City of Albuquerque Stormwater Construction Site Inspection Report

ESC File No.	J12E015	Project Name:	Bosque Antigua		
NPDES Id. No.	NMR1001OG	Location:	917 Gabaldon Dr.		
7/1/2021	Owner			Contractor	
Operator	Las Ventanas NM, Inc.,				
Contact name & title	Scott Ashcraft		Adam Romero		
e-mail	tscott@lasventanasnm.com		aromero@lasventanasnm.com		
Contact Phone #	505-800-3377		505-440-5277		
COA Inspector	Thomas Evans		Start/End Time:	9:45 AM-10:10 AM	
Construction Phase:	Home construction				
Type of Inspection:	Regular	Storm Event	Past Storm Event >0.25"	311/Complaint	Follow Up
Weather at time of inspection?	clear		Temperature:	~ 74	
Estimated date of last storm 0.25" or greater	6/28/2021

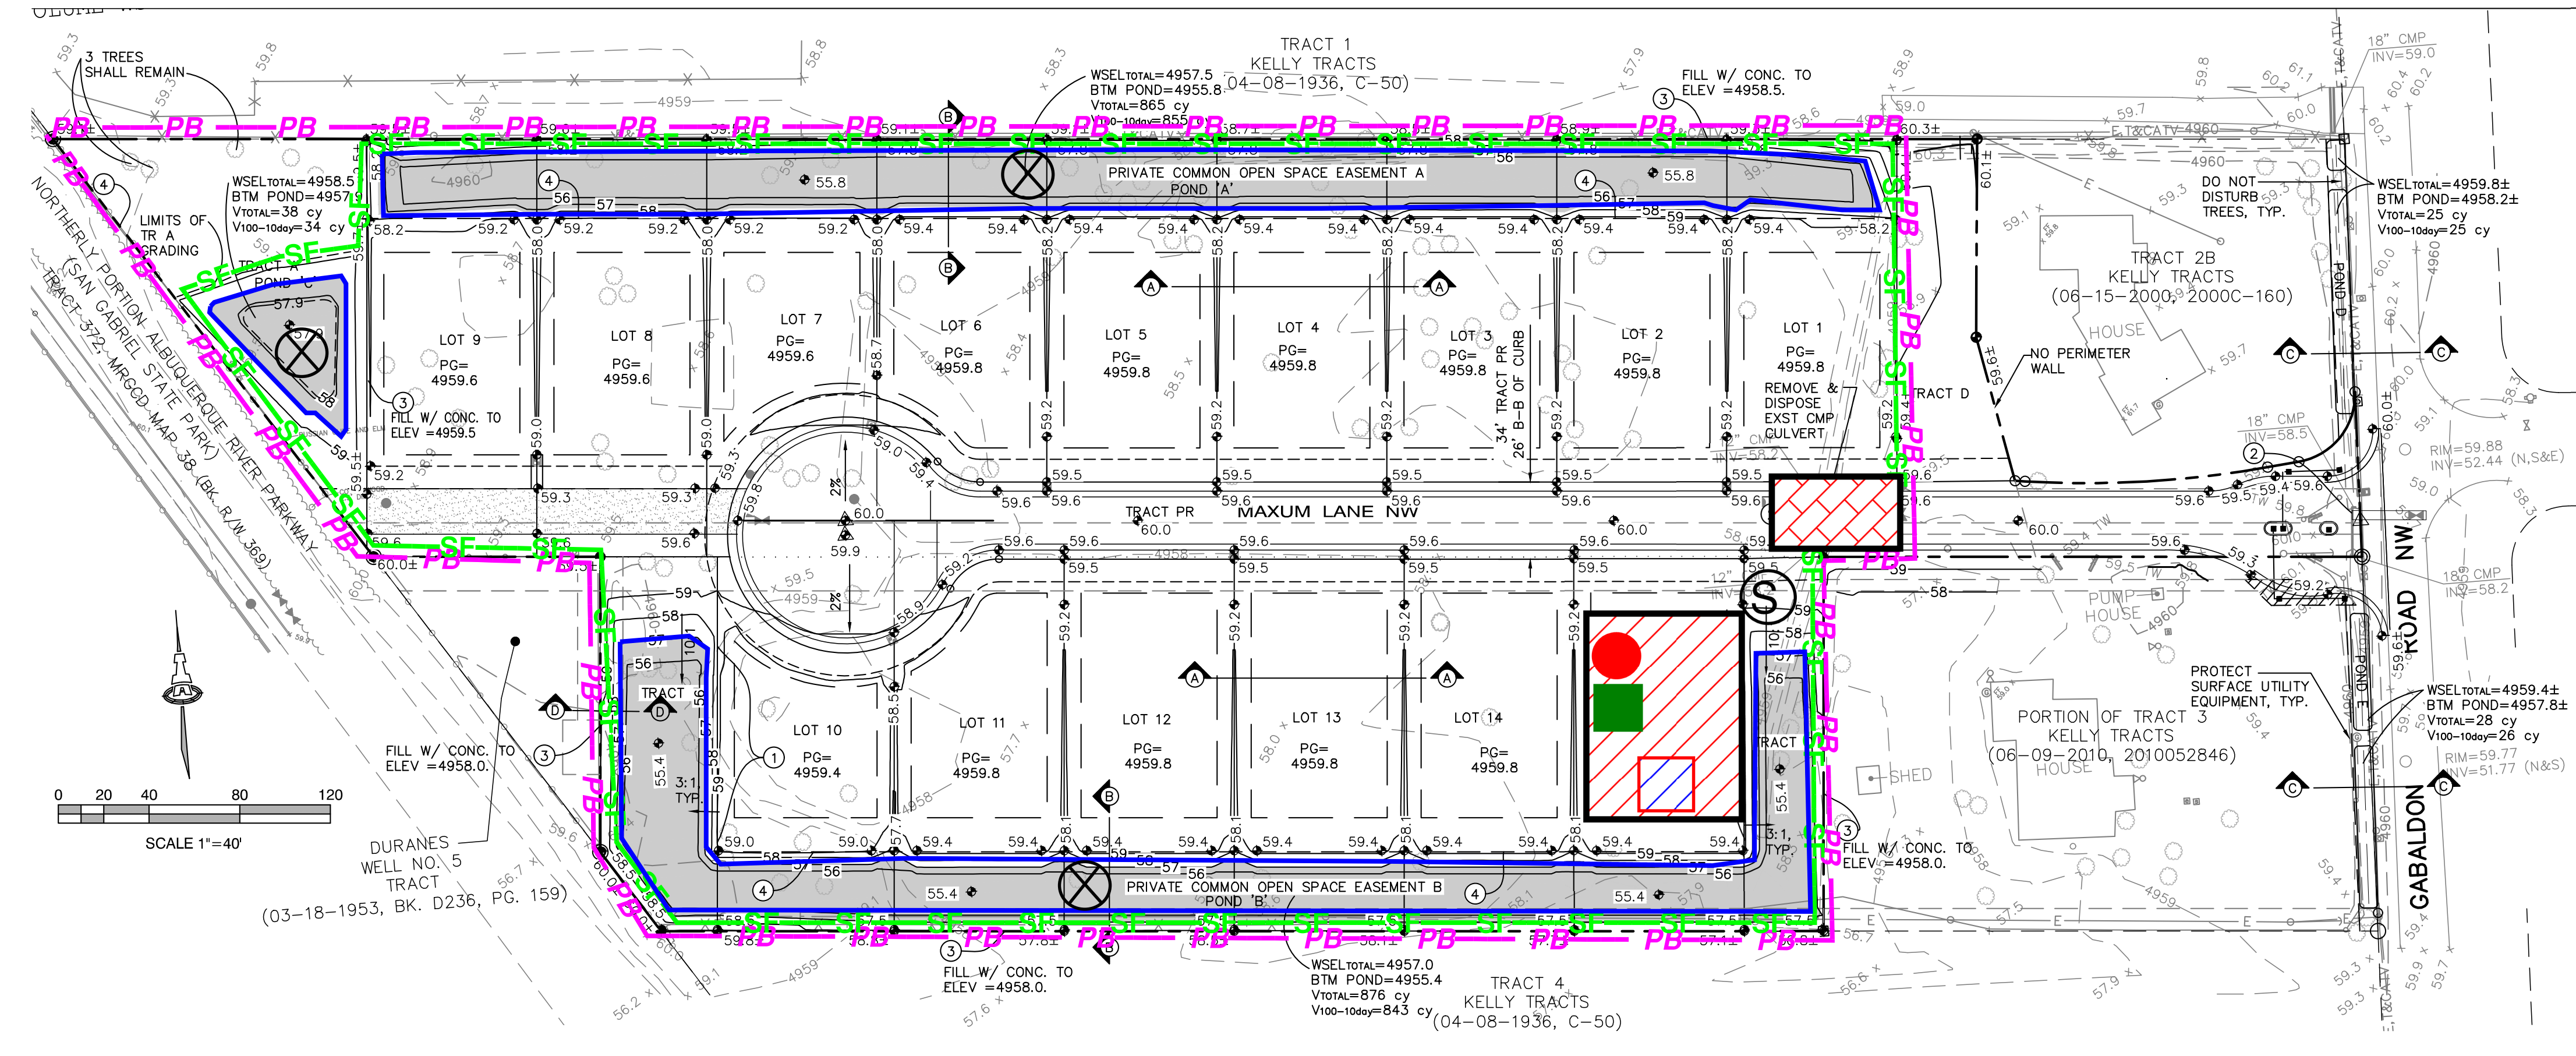
Item Number	Deficiency/ Corrective Action				
1	SWPPP not up-to-date. Update site map, activity logs, and file reports.				
2	Washout container is full. Empty washout container per CGP 2.2.3.				
3	Silt fence needs repair at West end of site. Repair/maintain silt fences.				
4	Implement temporary stabilization controls for inactive lots				
5	Implement permanent stabilization for pond areas at West end of site				
6	Waste containers are full. Empty waste containers once they are full.				
7	Provide latest self-inspection report.
